### Application for Removal or Variation of a Condition following Grant of Planning Permission or Listed Building Consent

Erection of a part single part two storey side and rear extension, insertion of two dormer windows to the front to facilitate the conversion of the loft.

22/00464/HOU

Drawing Title
 Elevations, Section BB details

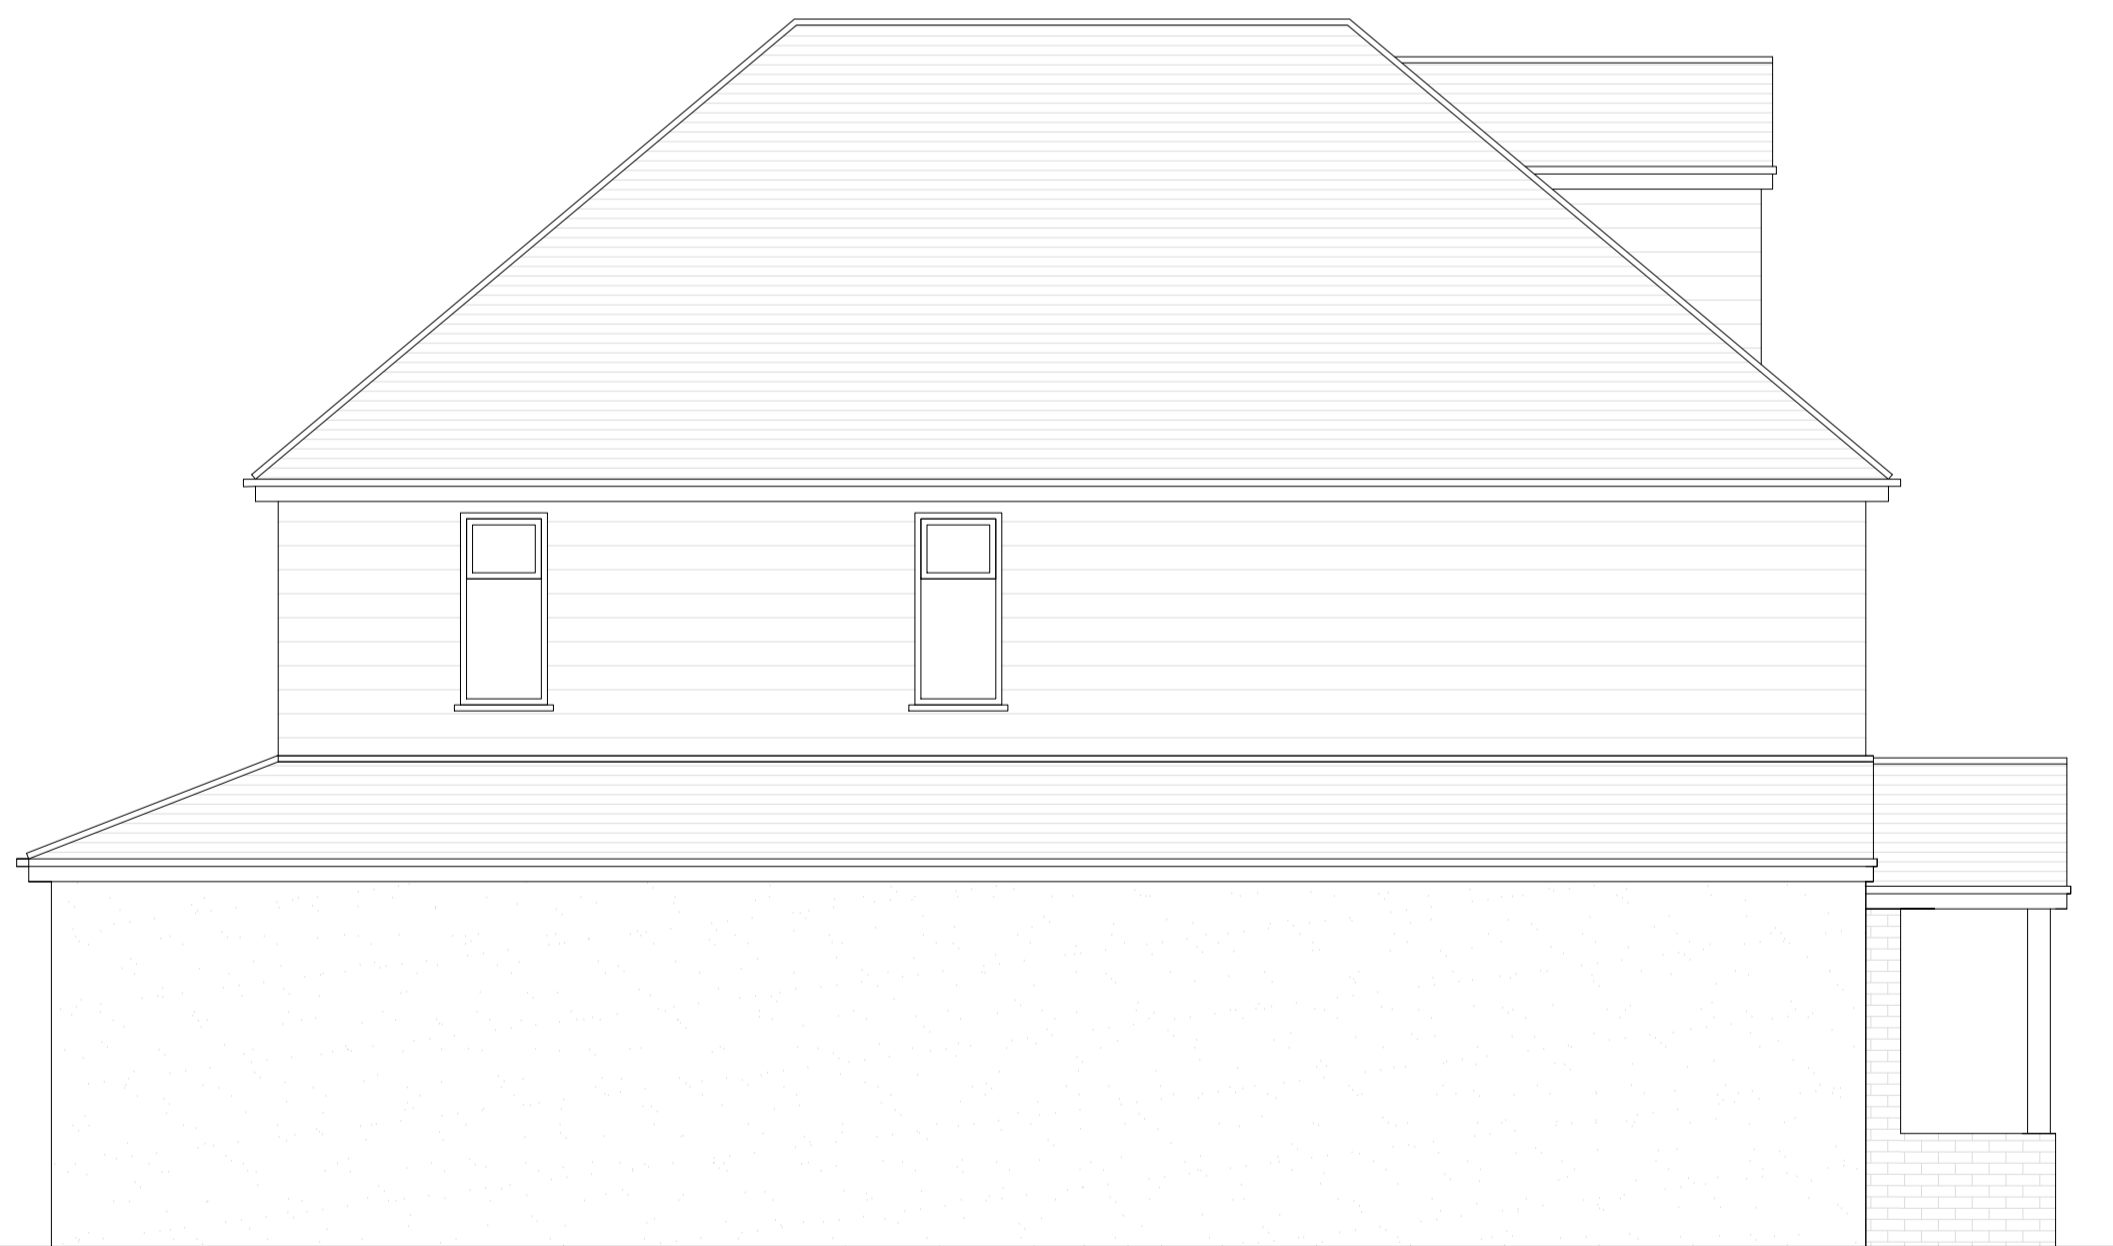
Side wall to be rendered not brickwork as per approved drawings.

Brickwork changed to brickwork.
